Planning Officer: Ms Myer

Planning Application Ref: BN/24/20/PL

Location: Tile Barn Farm, 32 Hill Lane, Barnham, PO22 0BL

Description of works: Erection of 1no. dwelling & formation of new vehicular access. This application is a Departure from the Development Plan

PROPOSED SITE
Dwg. No. 06

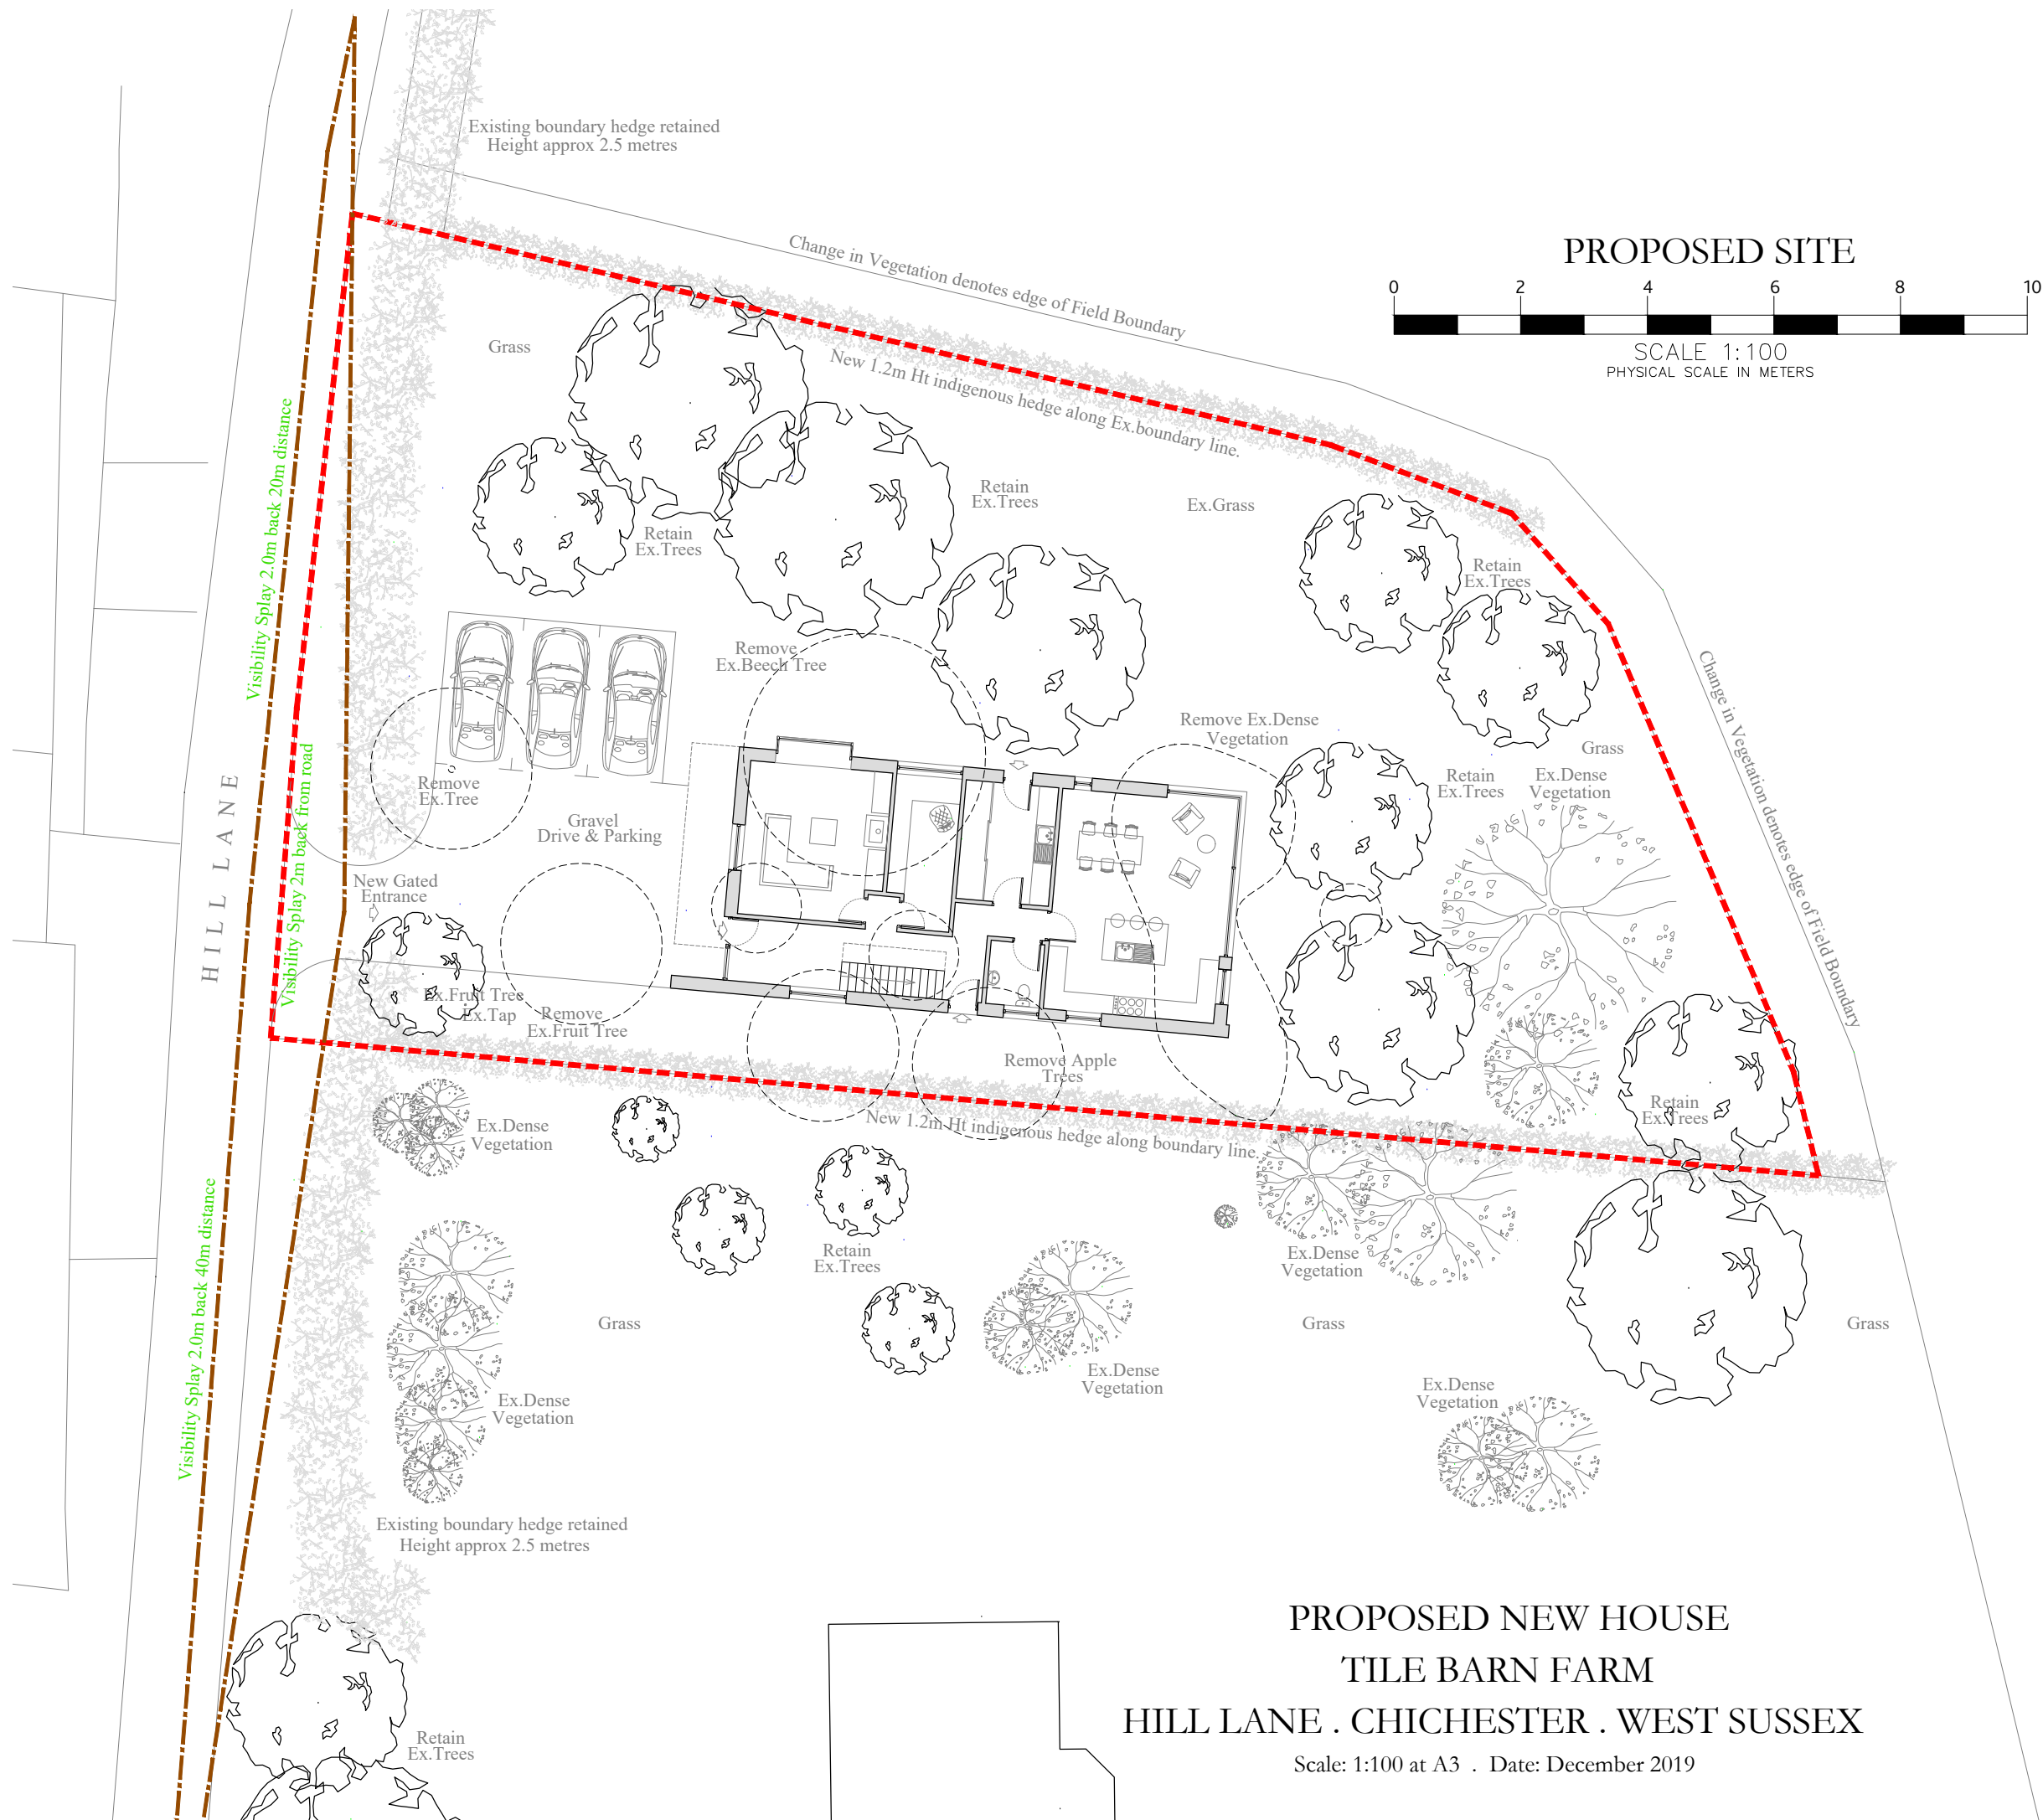
- Further details of the indigenous hedgerow planting scheme (north and south boundary of new plot) as shown on Proposed Site dwg. no. 06 would be required, for it to be effectively included in a condition forming part of any APPROVAL.
